From: Neil Crowther
Sent: 24 August 2018 11:58
To: Planning.Responses
Subject: FW: WA/11/18/DOC
Attachments: YE2996 - Appendices.pdf; YE2996 - Report.pdf; YE4674 Factual Letter Report.pdf

Condition 9:

Subject: Progress Garage, Yapton Lane, Walberton

Scale 1:200	Drawn By SPB	Checked By MJA	Approved By MJA
Date April 2018	Drawing No. 2017-D1337-001		Rev. A

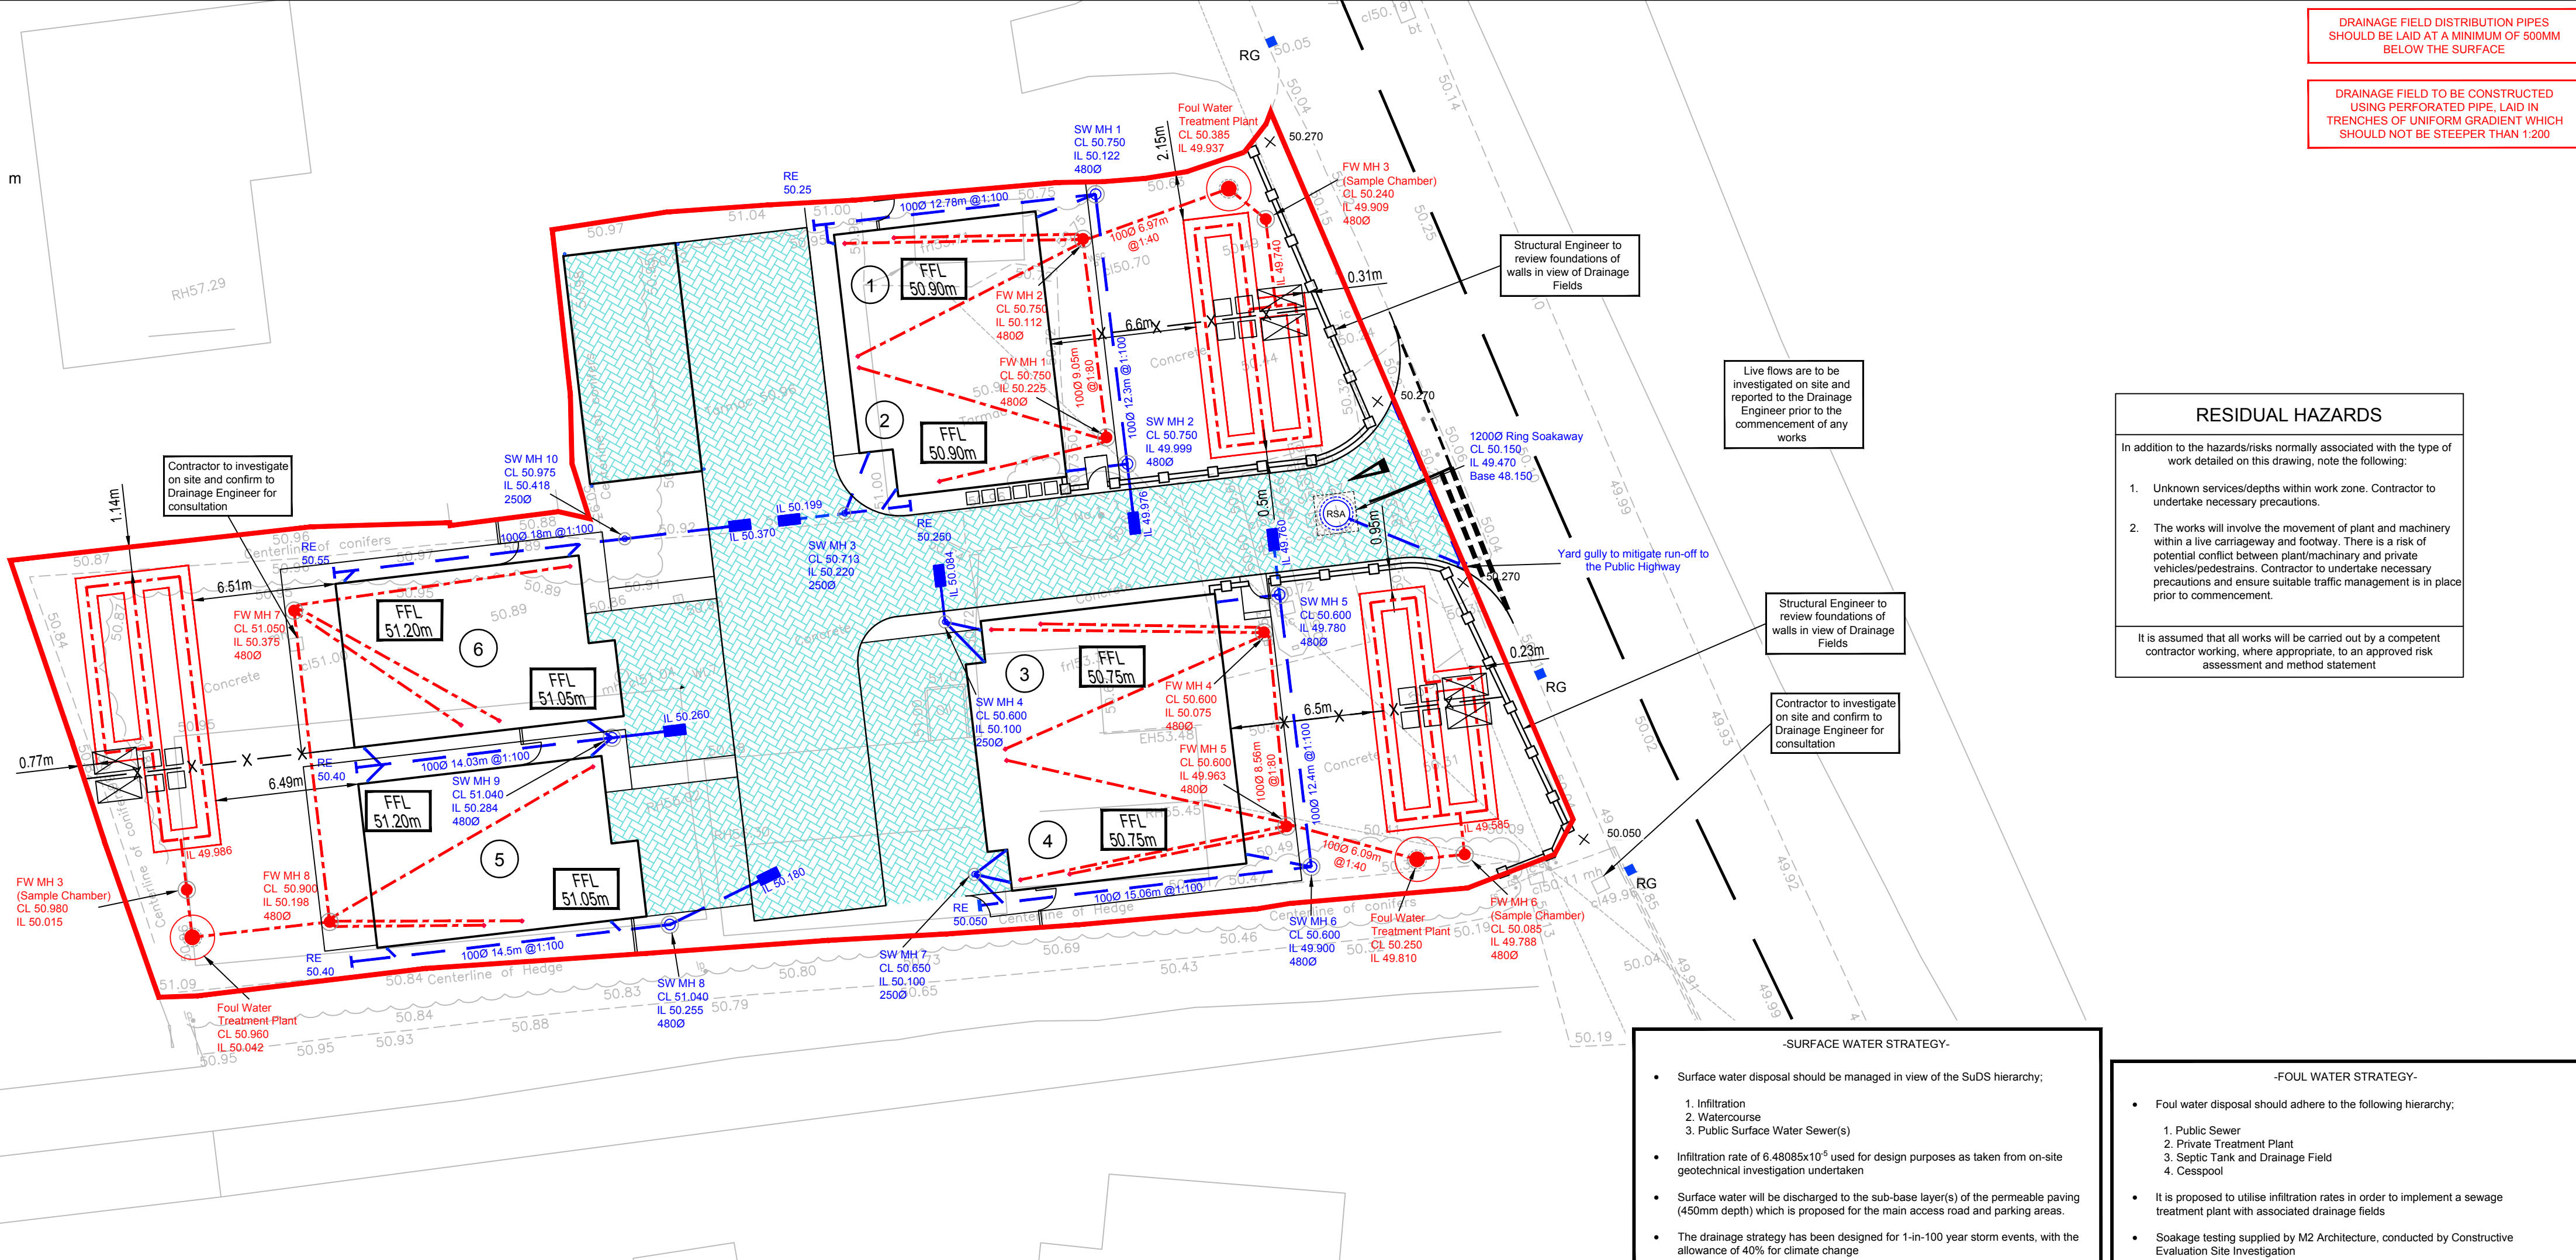
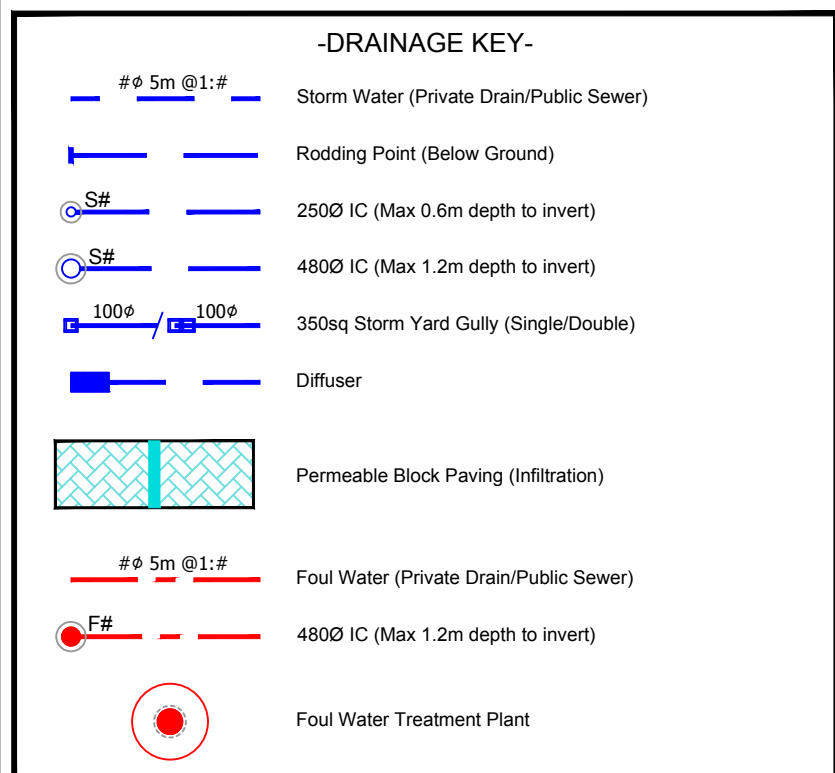
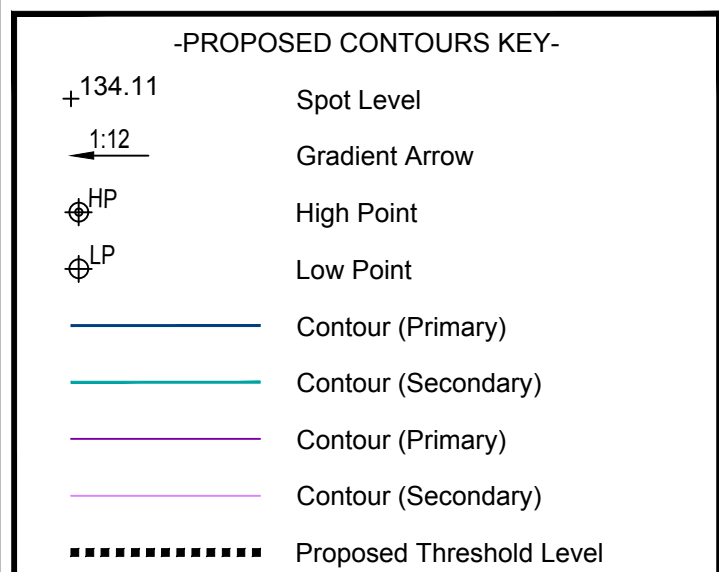
1. The Planning Decision Note states that planning was granted on 2 March 2017, meaning groundwater monitoring could have been undertaken during the winter period in late 2017/early 2018. That said, Knightgate have only acquired the site relatively recently and were therefore not in a position to be able to undertake the testing during the requested period. Although I understand Paul's request, it could be unfair to delay construction works for around 12 months on the basis of groundwater monitoring, given that Knightgate were not in a position to conduct this during the requested/required season. Of the information provided to us by yourself, the previous land owner did have some geotechnical investigation undertaken. I have attached the trial pit logs which formed part of the infiltration and soakaway testing conducted by Constructive Evaluation which state the level(s) at which groundwater was encountered. I can see Paul has stated this was conducted outside of the recognised winter period although Mark and I believe that the information available to us would suggest there is low risk of groundwater flooding.

2. I have attached all current drawings which you should already have – the only changes are to drawings 001 and 004 which are now both Rev. A following the decision to include a ring soakaway within the permeable paving to ensure we hit the penetrable strata underlying. The drawings and calculations provided should be all that is required in order to satisfy this point.

3. All of the requested and required information can be found on the drawing provided (001 Rev. A).
